RE: Section 75W Application to Major Project No 08_0069
Potts Hill Reservoir Site – Response to submissions

We write in response to the submissions received by the Department of Planning with respect to the Section 75W Application to Major Project No 08_0069. This response is written on behalf of the applicant, Landcom.

Table 1 Response to submissions

Figure 1.2 Potts Hill Reservoirs Site Proposed Development Footprint (Prepared by Architectus)

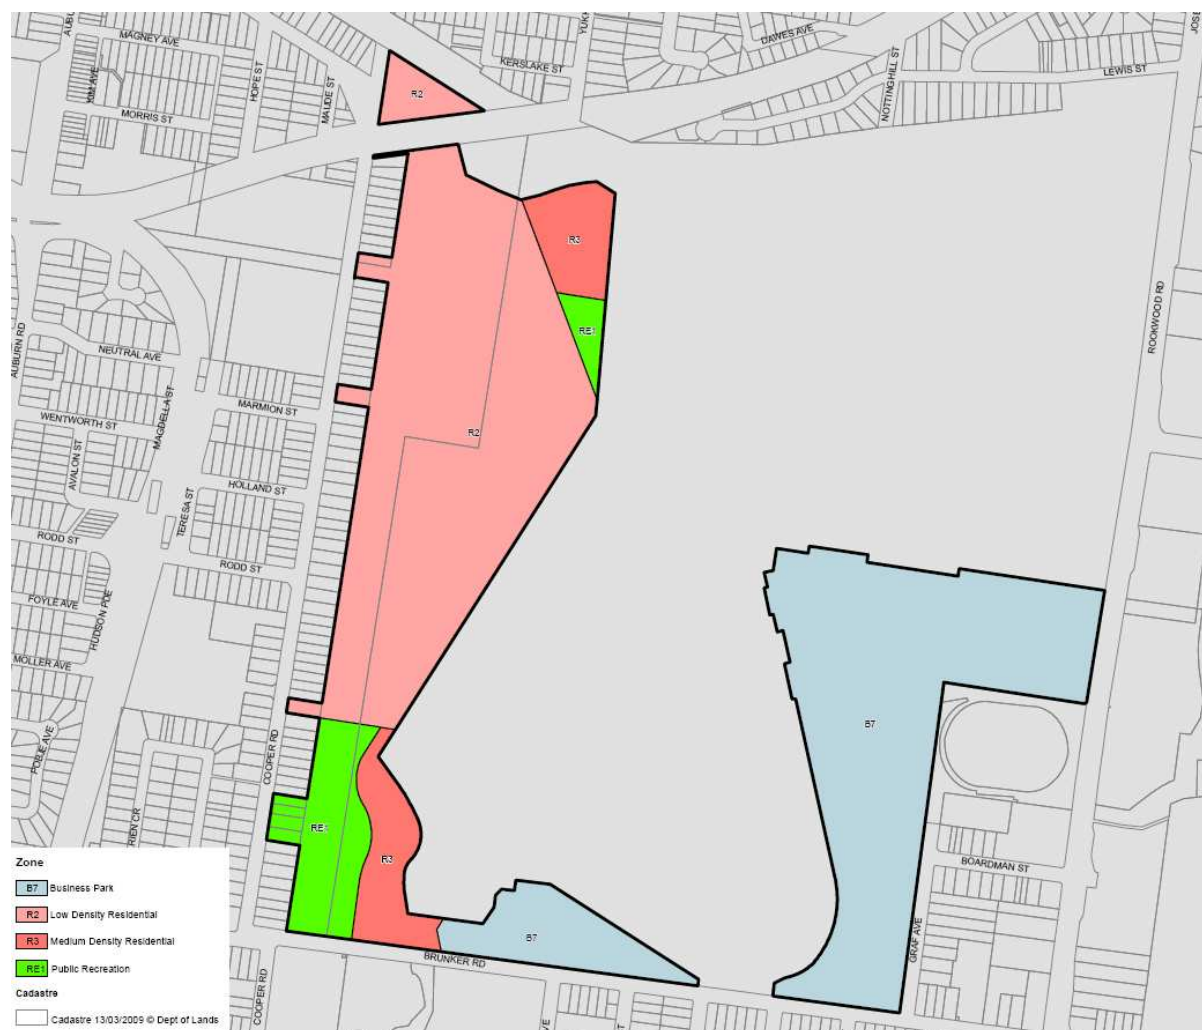
Submission comment	Propponent comment
Department of Environment, Climate Change and Water submission	
Construction Environmental Management Plan DECCW requires that the CEMP be amended to contain the approved Concept Plan and that all Environmental Management Plans and Sub-Plans be reciered to ensure they reflect the approved Concept Plan boundary and development footprint.	The CEMP has been revised to reflect approved Concept Plan boundary and development footprint. It is noted that the CEMP only applies to land within the approved Western Residential Precinct boundaries. The revised CEMP is provided at Attachment A to this response.
Preliminary Air Quality and Dust Management Sub-Plan The following additional information is required to make a full assessment of air quality and dust management: <ul style="list-style-type: none"> • Identification of sources and quantification of airborne pollutants (including dust and exhaust emissions); • Identification of nearest sensitive receivers; • Mitigation measures to minimise impacts. 	The requested air quality and dust management details will be provided as part of the Final CEMP to be prepared following the appointment of a contractor to undertake the proposed demolition and remediation works in accordance with the Preliminary CEMP prepared by Cardno. This may be required as a Condition of Consent to this application.

A Revised Preliminary CEMP has been provided at **Attachment A**, to reflect the approved Concept Plan boundaries as required by DECCW. Revised Landscape Plans have also been provided in response to comments from Bankstown City Council.
